Planning Application Ref: FP/228/21/T

Location: 11A Outerwyke Avenue, Felpham, PO22 8JH

Description of works: Reduce all limbs on 1no. Turkey oak by 2m to leave 6m

11A OUTERWYKE AVE

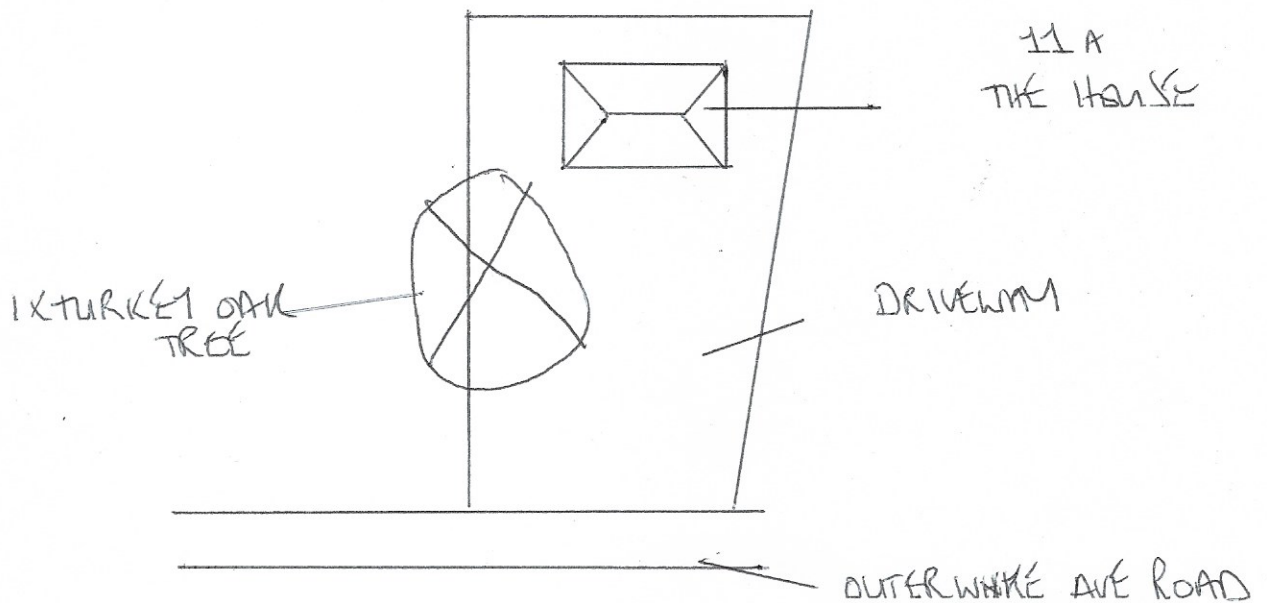
- The tree has been incorrectly identified, although it is clear from the description of works and sketch plan which tree is the subject of this proposal.

- Taken literally, this proposal seeks to reduce all limbs by 2metres; that to be consistent with previous works would involve reducing height and spread. As such, it is important to specify the finished height dimension.

- This tree requires careful management that respects its age and vulnerability to environmental changes and disease progression.
- The work proposal is ambiguous as it does not provide finished measurement of height. If enacted to the same extent as to be applied to crown spread, it would leave a post-pruning height of c12metres and not the stated 6metres. The latter would result in a damaging loss of crown volume and amenity.

- As it stands, I recommend refusal for this application. However, **I would like the applicant to be invited to agree to a revised work specification** (such as described below) **and as part of the current application so as not to incur further delay.**
- *Prune to reduce overall height and spread on all aspects by no more than 2metres, leaving a minimum finished height of 12metres and radial spread of 6metres.*
